Submission ID: SF6D52302

FGE Landscape & Visuals & ASI

The importance of the impact of the FGE development on the Landscape cannot be overstated and therefore we request that:

Drawing file: published-documents / EN010154-000142-6.2 Fig 3-6B Indicative On Site Substation Elevation.pdf

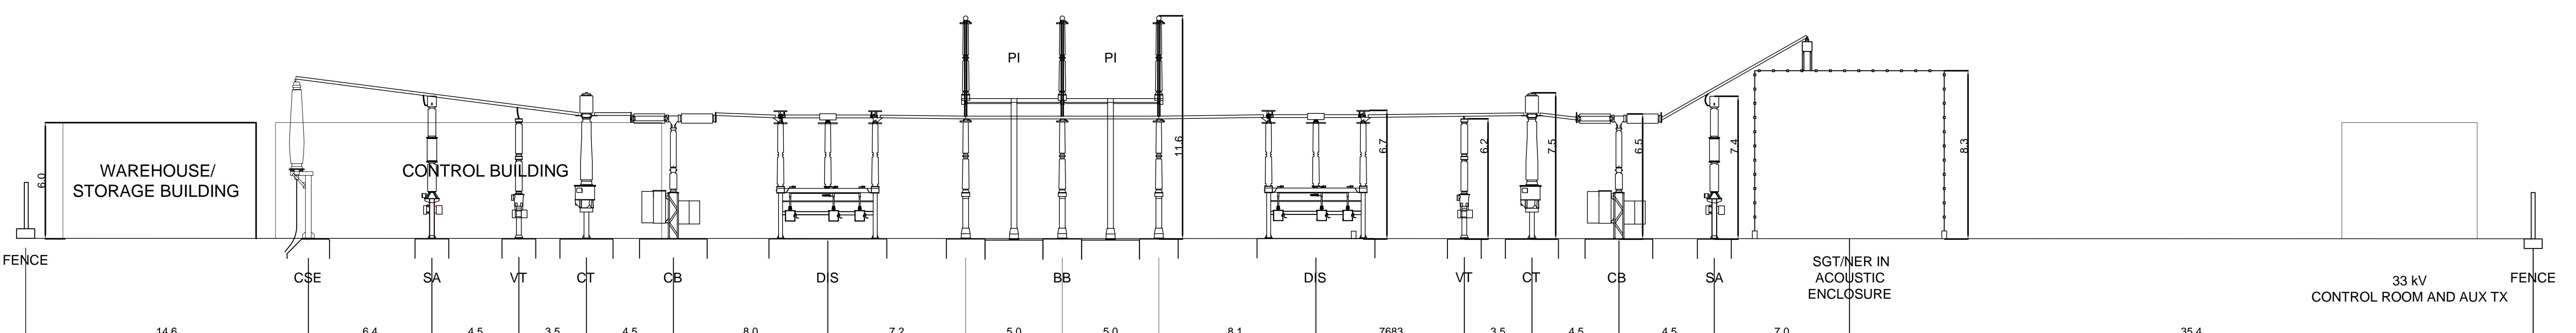
Aubourn Moor - Substation Site

The Substation and solar panel arrays either side of, and alongside the footpath to the south will have a significant impact on the ProW and promoted Aubourn & Bassingham Long Walk in this location. This is another example of poor design, with no real attempt to mitigate these impacts in the design solution here.
